AGREEMENT WITH LUC

File Note

Land at Junction 10, M40 – LUC comments on Tyler Grange response

Sender	Recipient(s)
David Hope, Rebecca Knight	David Lowin, Robin Forrester
Project Number	Date/Time
11851	17 May 2022

Project No:	14047	Date:	July-21
Client:	Albion Land	Project:	Land at J10, M40
Status:	For Information	Figure:	Baseline Views

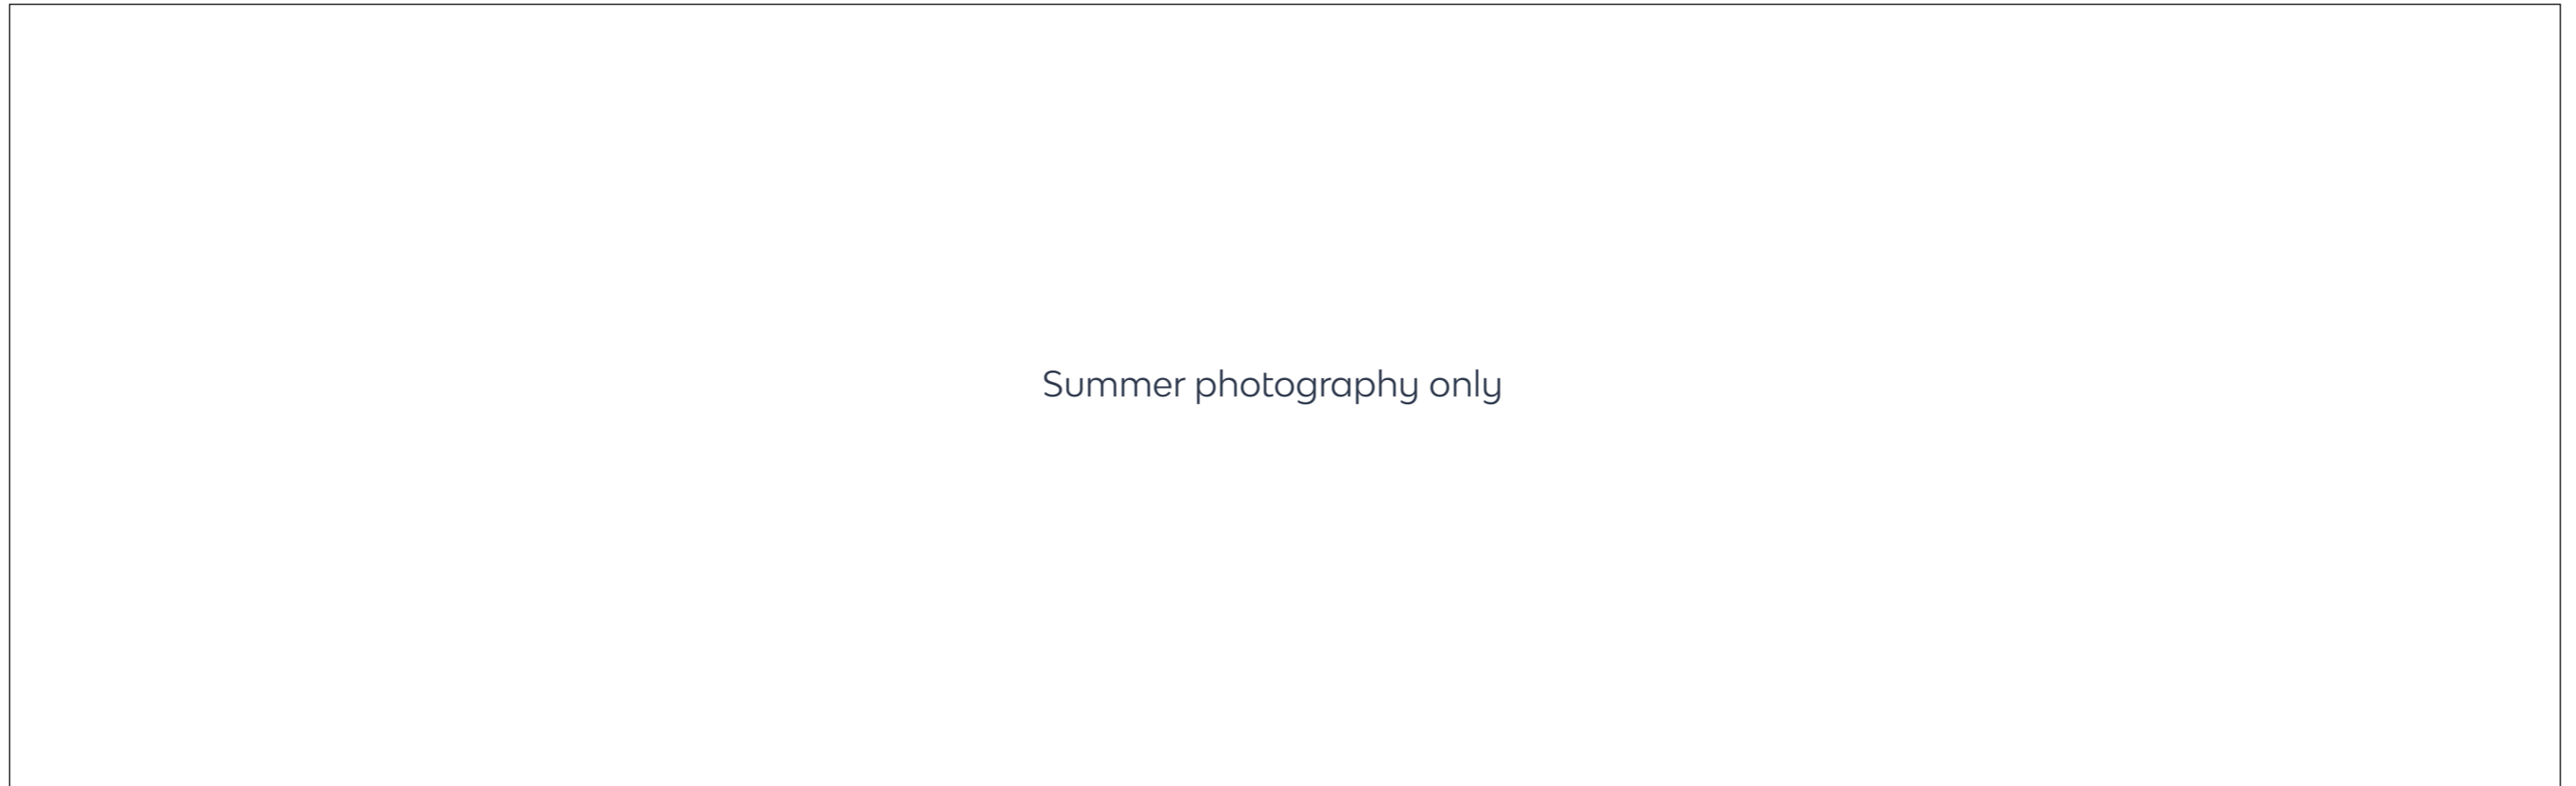
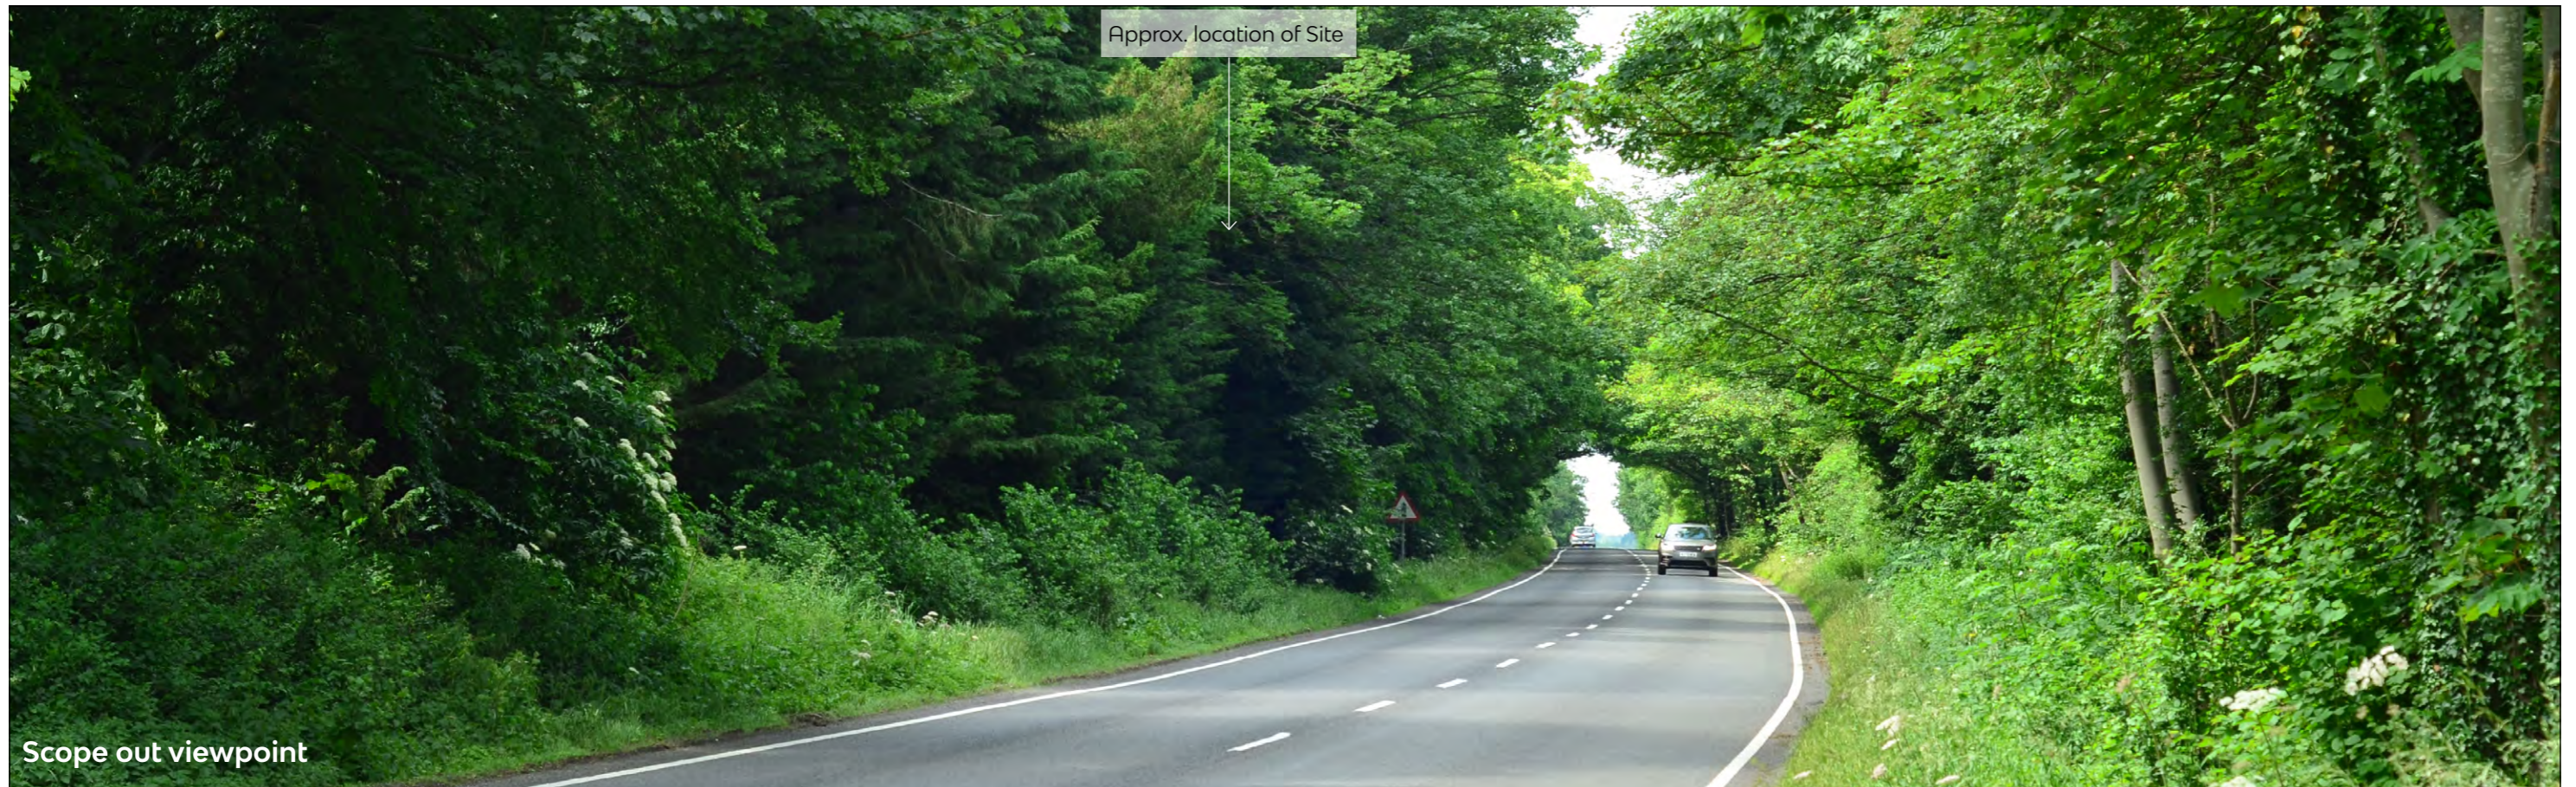
6	The LVIA should include an assessment for the omitted visual receptors (as set out in paragraph 2.11 to 2.13. above).	Justification for de-scoping receptors using the M40 and A43 is set out in Appendix 13.5. Assessment of receptors using the B4100 north of the Site and using Jct 10 of the M40 will be included in the LVIA update.	Re users of M40 and A43 - Appendix 13.5 does not contain any justification text, just the scoped out images. The justification should be included in the updated LVIA. Re users of B4100 and Jct 10 of M40 - Acceptable.
7	The Applicant should confirm that the assessment has considered the worst-case scenario of winter conditions for all receptors, and make this clear in the assessment.	We will review the LVIA to ensure that the assessment of effects is clear is that it assumes the worst-case scenario.	Acceptable.
8	The applicant should review the judgements made on effects during the enabling works, construction and operation, to ensure none have been under reported.	As part of the planned update to the ES Chapter we will review the judgements of effects.	Acceptable.
